Engineers Comments Regarding Surface Water Drainage

Application Reference:	AB/145/25/DOC	Reviewer Reference:	ADC/EXT4b
Planning Officer:	Kathryn Welch	Date of Review:	02/04/2026
Site Name:	Electricity Sub Station And Gas Valve Compound Ford Road Arundel BN18 9FN		
Application Description:	Approval of details reserved by condition imposed under AB/88/19/PL relating to condition 4-as built drawings concerning drainage.		
Assessment Number:	2 of 2

Application Reference: AB/145/25/DOC Site Name: Electricity Sub Station And Gas Valve Compound Ford Road Arundel BN18 9FN	Initial Issue Date: 27/03/2026 Issue Date: 02/04/2026 Reviewer Reference: ADC/EXT4b
--	--

Inspection report

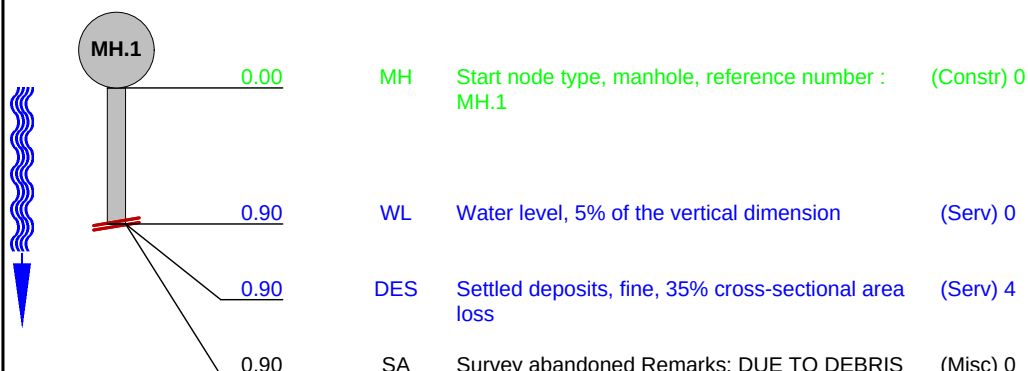
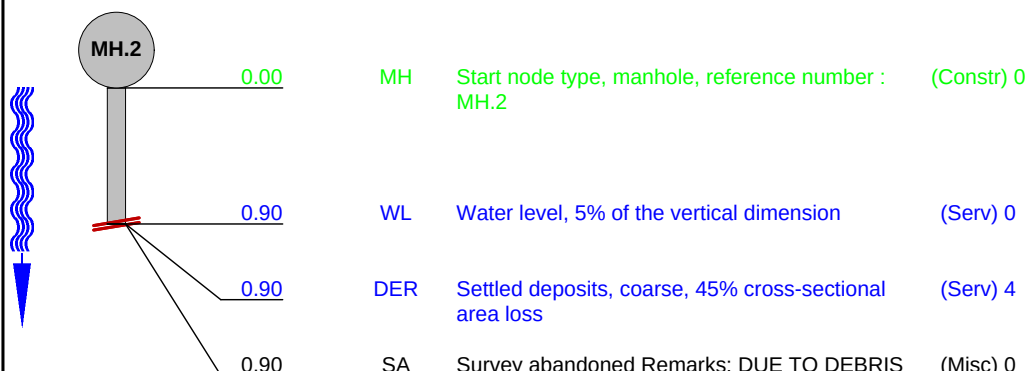
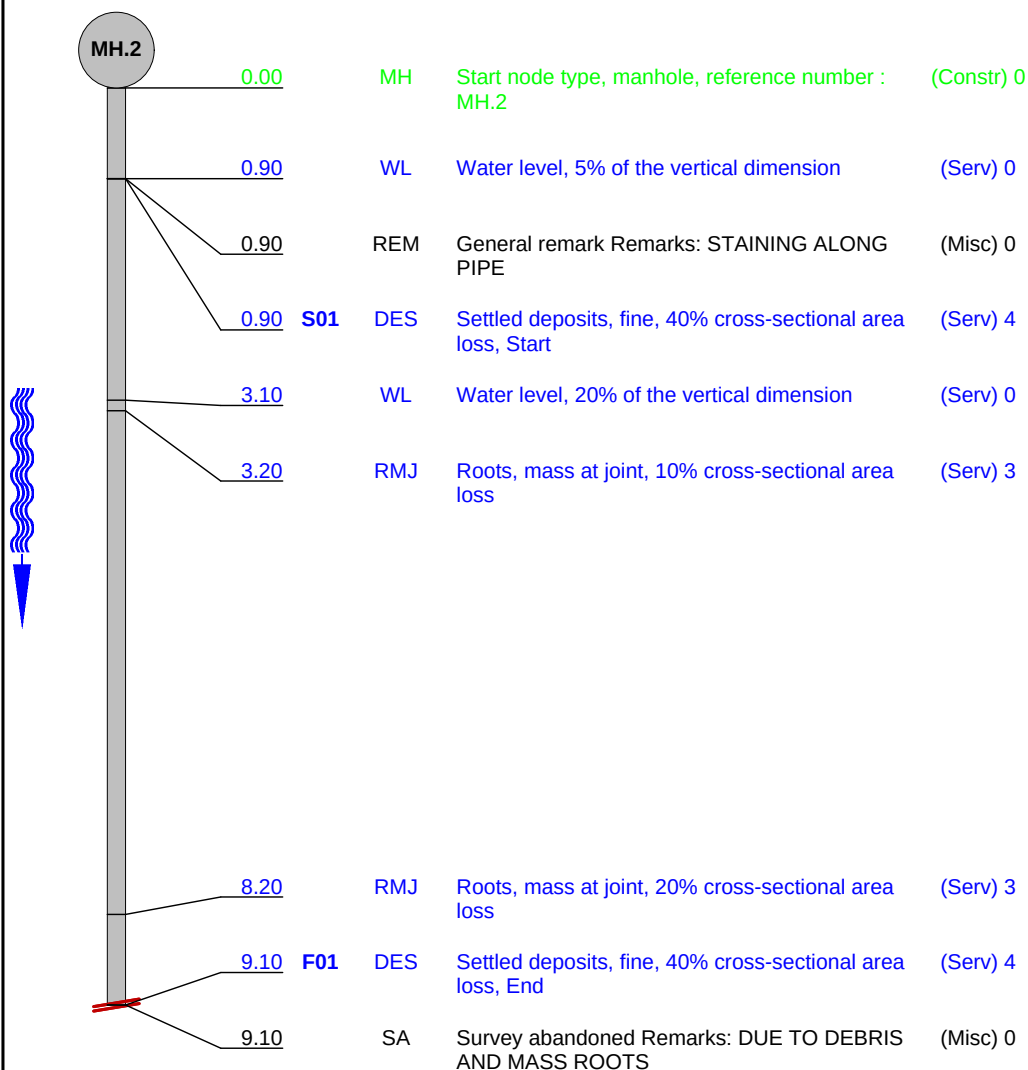
3.	Provide an as-built survey of the installed main principle surface water drainage network.				
4.	Provide CCTV survey of the principle surface water drainage.	CCTV of the FW drainage has been submitted. The CCTV survey demonstrates that there is construction debris in the pipes which needs to be cleared. Further questions (objection) relating to the Hydrobrakes in comment 12.
